SUBMISSION

Rye Park Wind Farm Modification 1 SSD-6693 – Mod 1

1. I write as the owner of “Wattle Vale”, to object to proposed Modification 1 to Development Consent SSD-6693 for the Rye Park Wind Farm. My objections are on the grounds of visual impacts, noise impacts and biodiversity impacts as set out below. This submission has been prepared with the benefit of advice of senior and junior counsel specialising in environmental and planning law.

Location of Turbines to be Removed

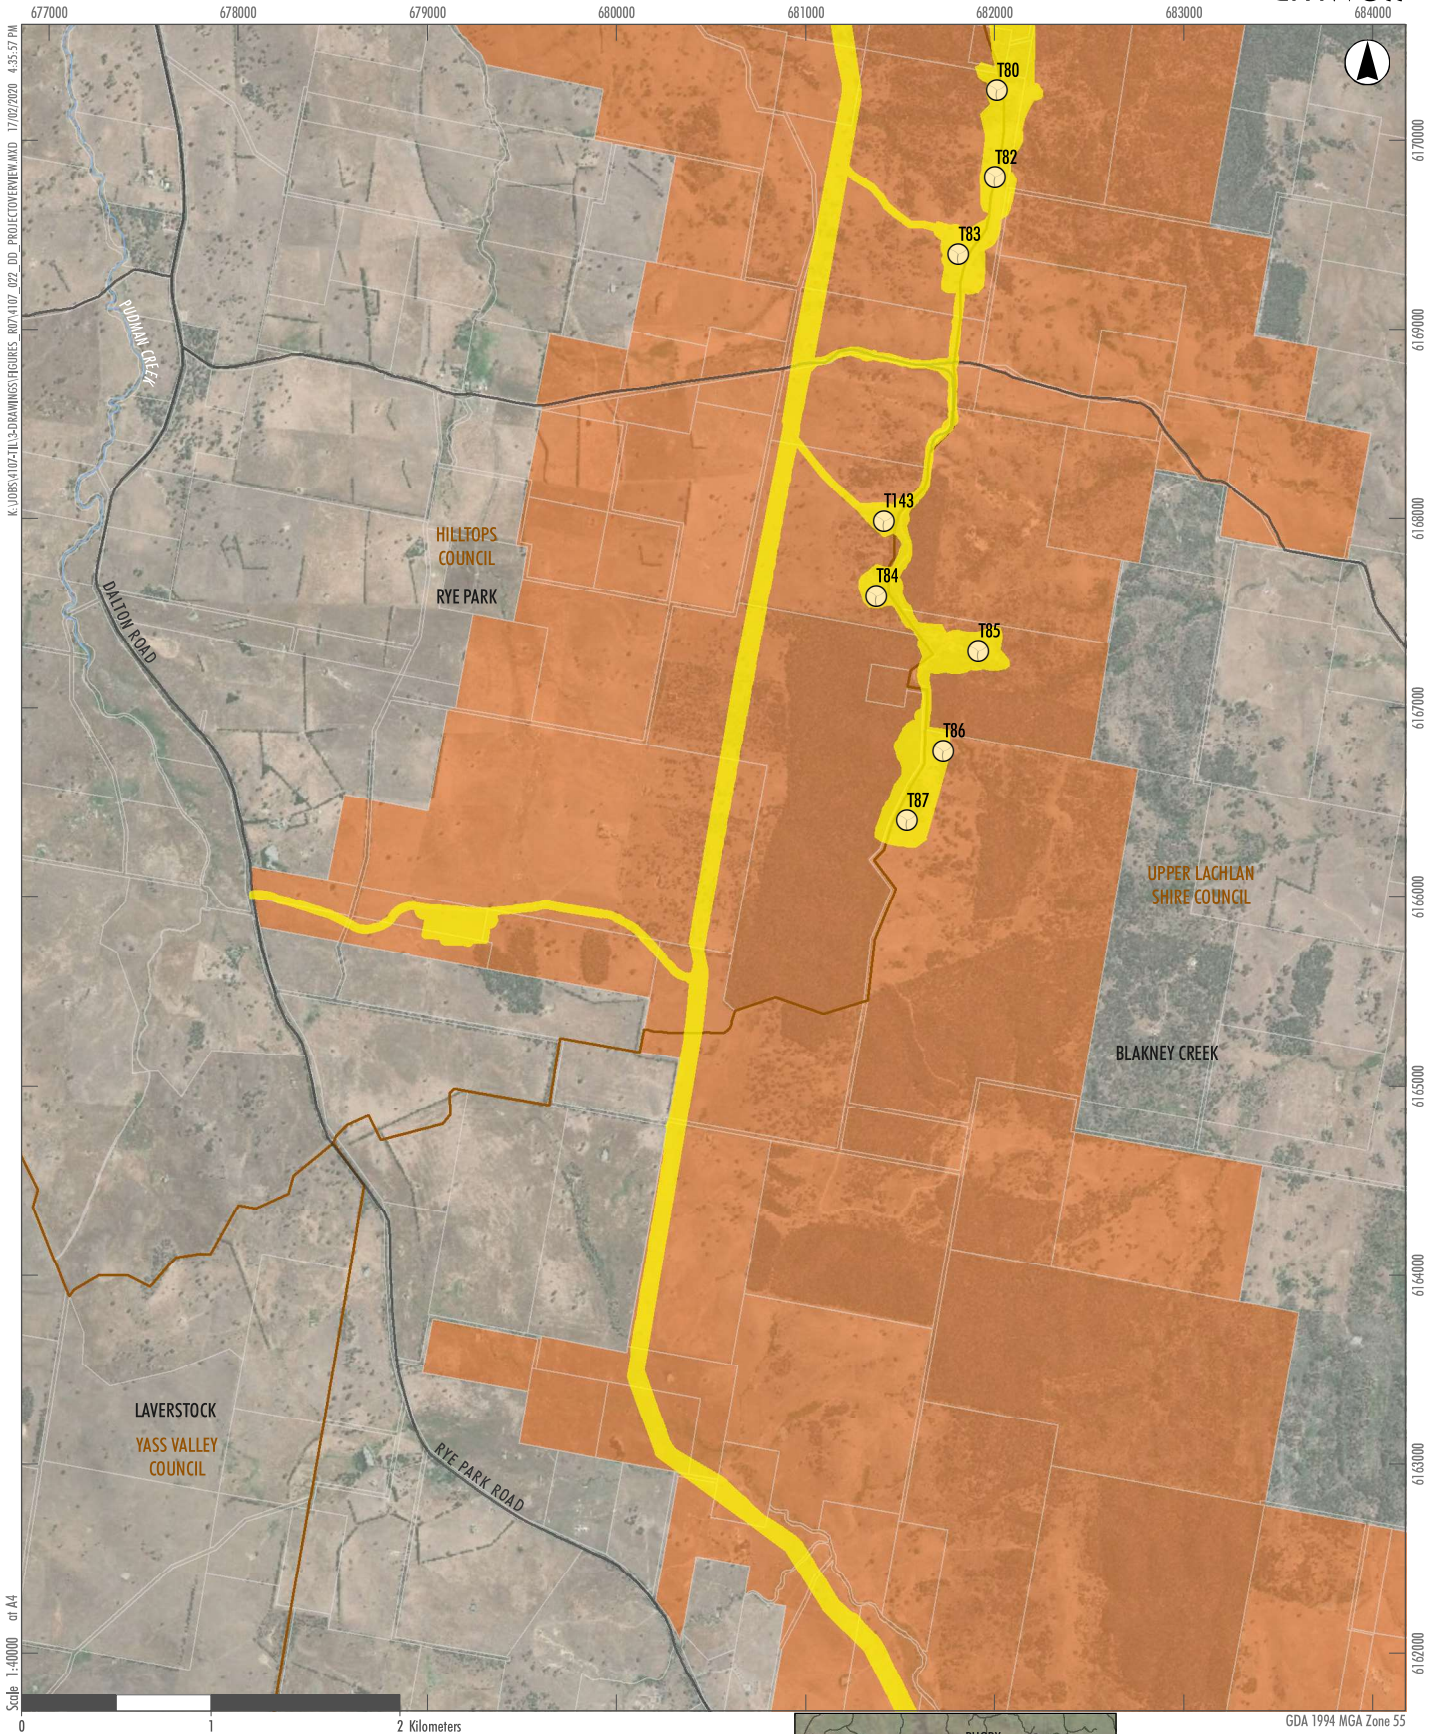
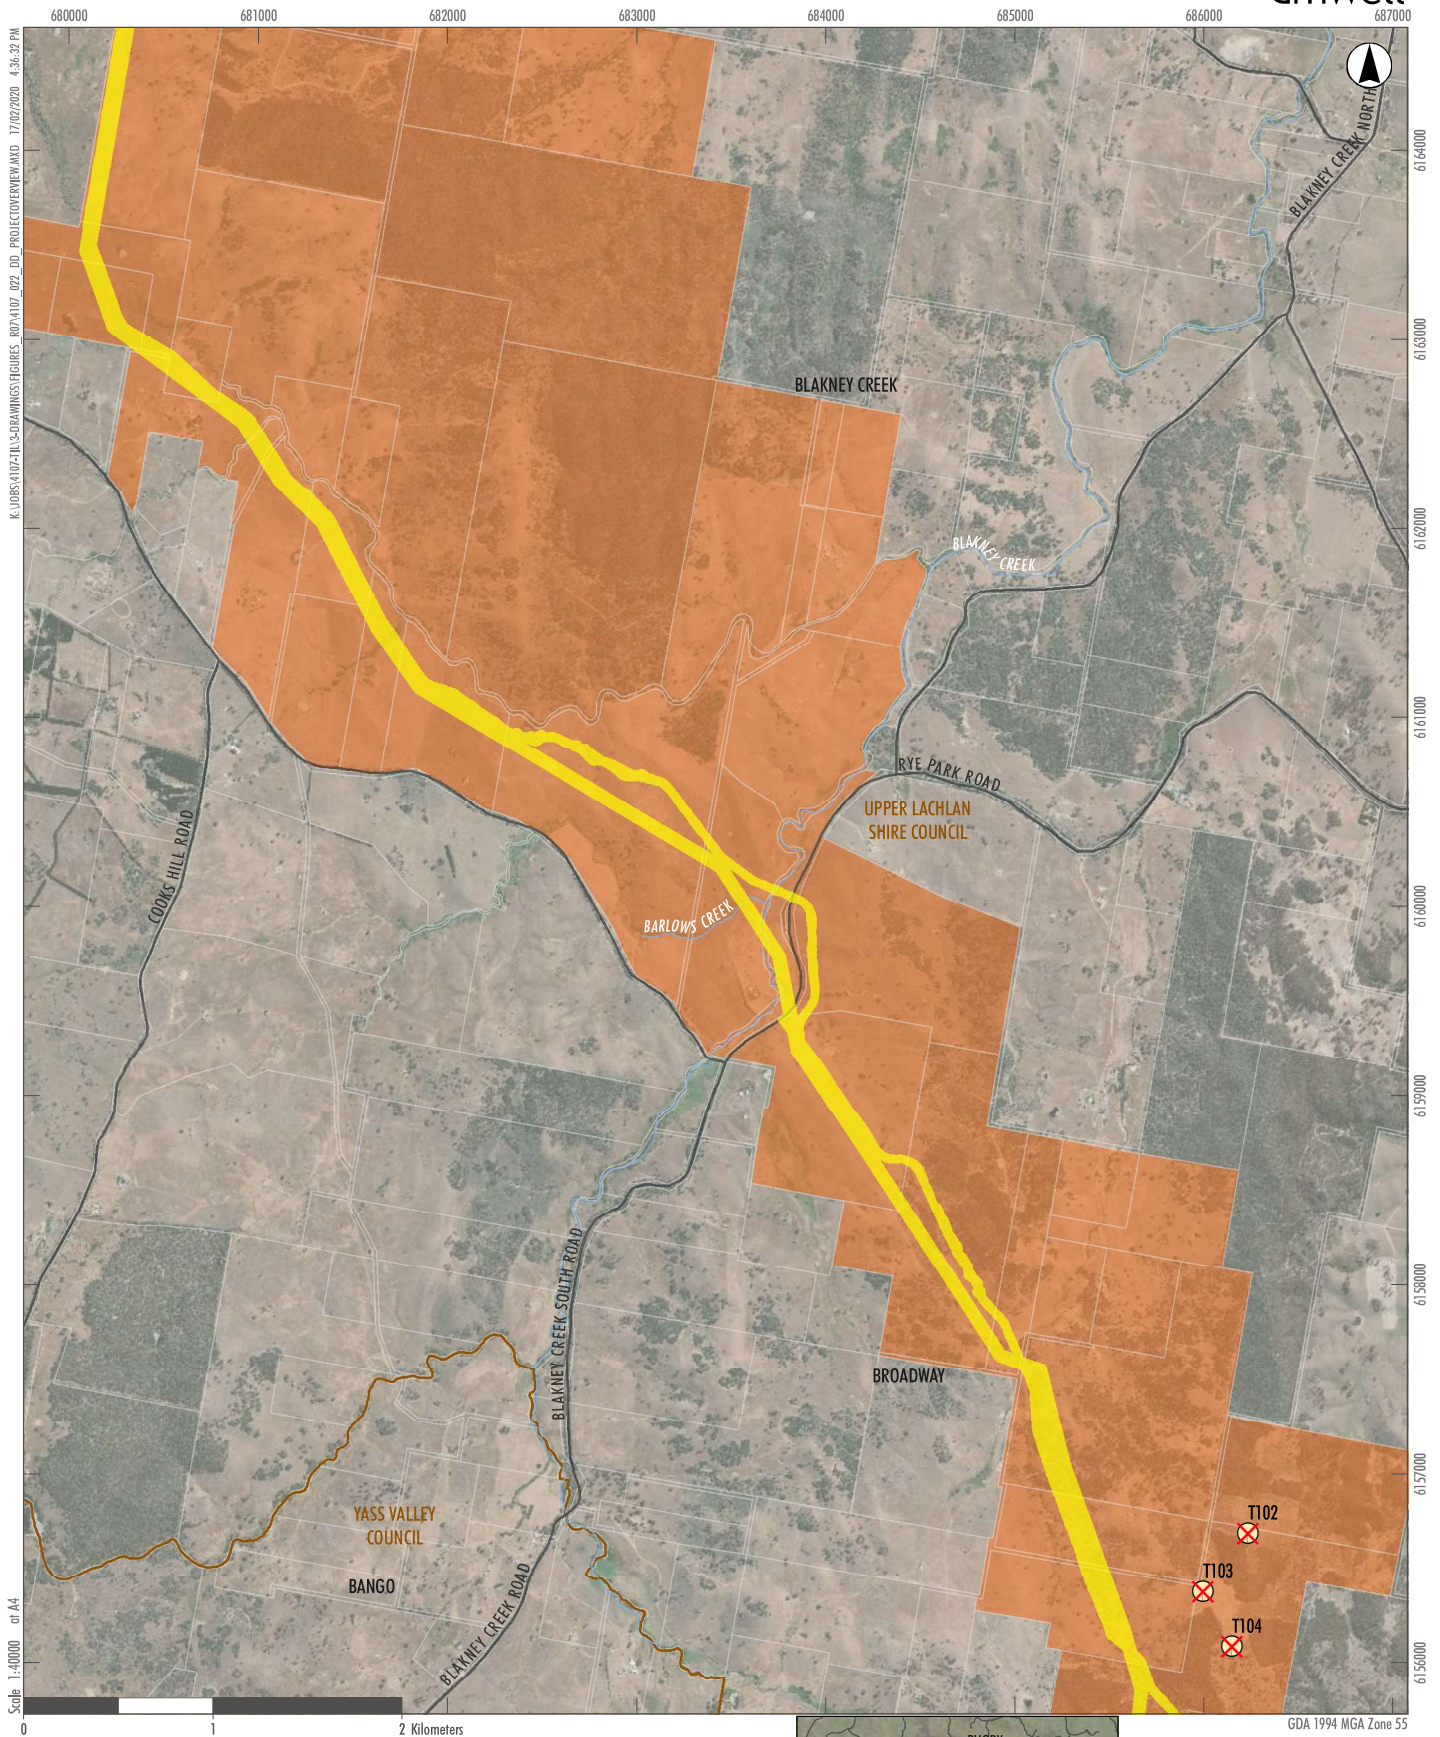
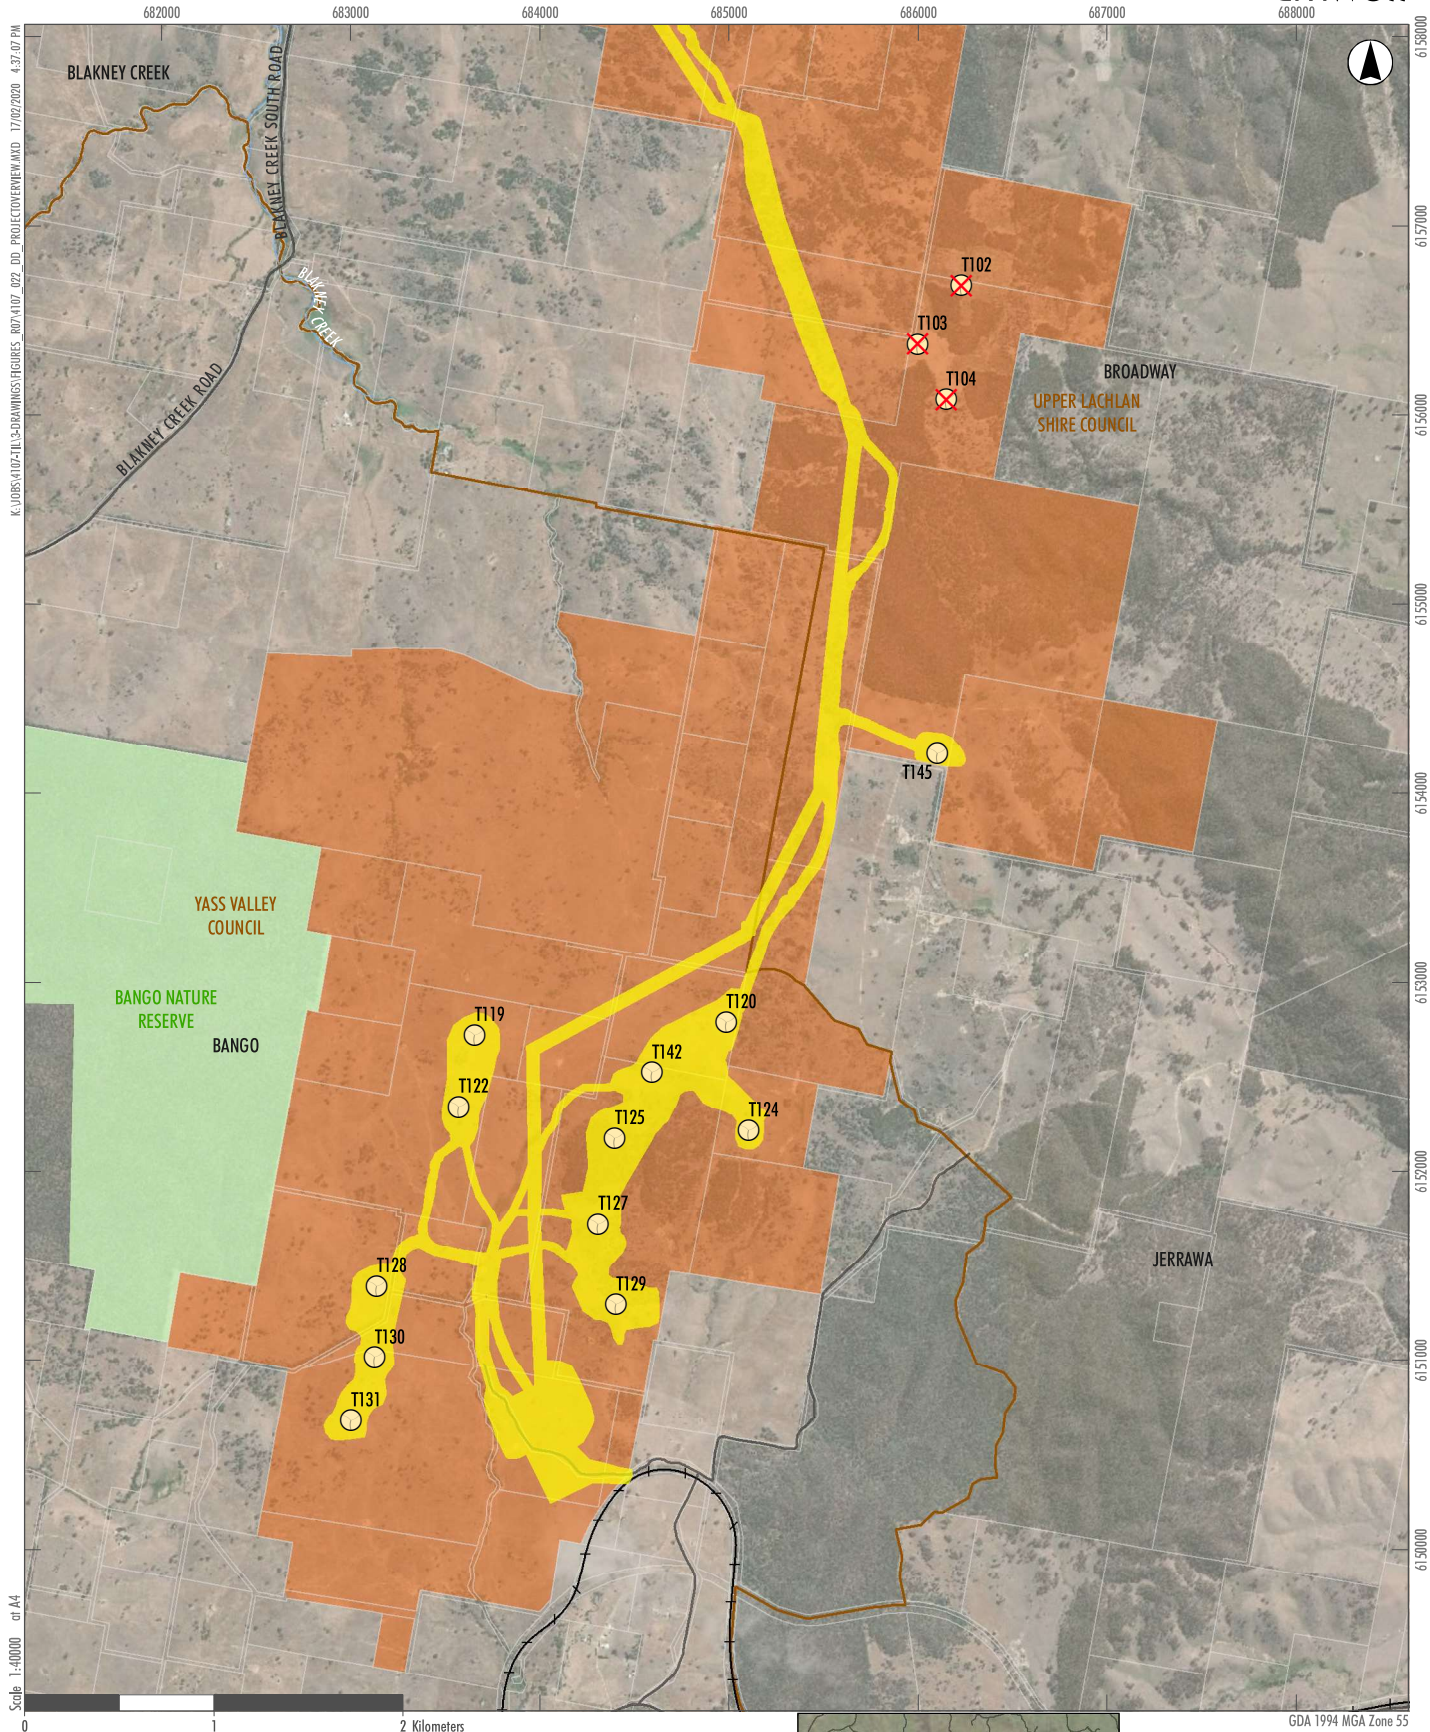
4. The VIA at Fig 1 and 2 contains a plan of the turbines which are to be deleted. However, this actually shows the difference between the Response to Submissions proposal and the modified proposal, rather than between the approved and modified proposal. Thus, it gives the impression of more turbines being deleted as part of the modification application than is actually the case.
